Department of Public Health

January 12, 2007

Re: Status of Improvement Permit Application #06-5-15934 - Lt 15 - Colonial Hills
#06-5-15947 - Lt 29 - Colonial Hills

-SITE PLAN FOR-

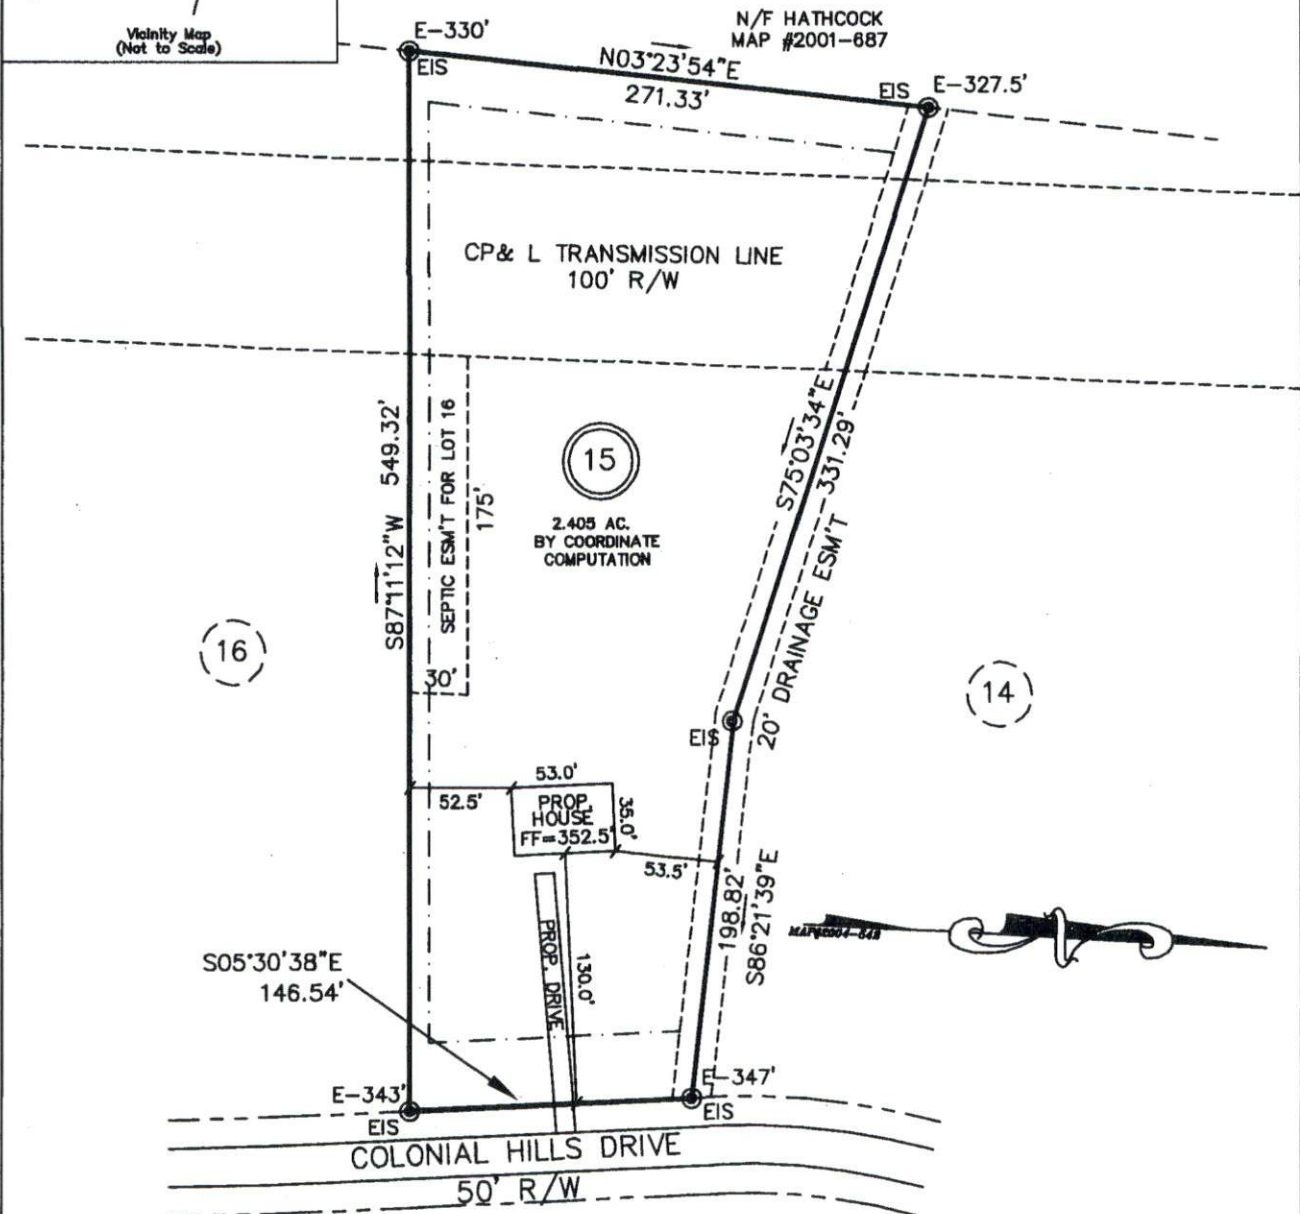
- 1. Property lines/corners not marked or labeled
- 2. House corners not marked or labeled
- 3. Directions not clear to property
- 4. Property needs brush or vegetation removed
- 5. Backhoe pits required
- 6. Other - Please change house location for lot 15 and lot 29 and submit new plot plan to Central Permitting.
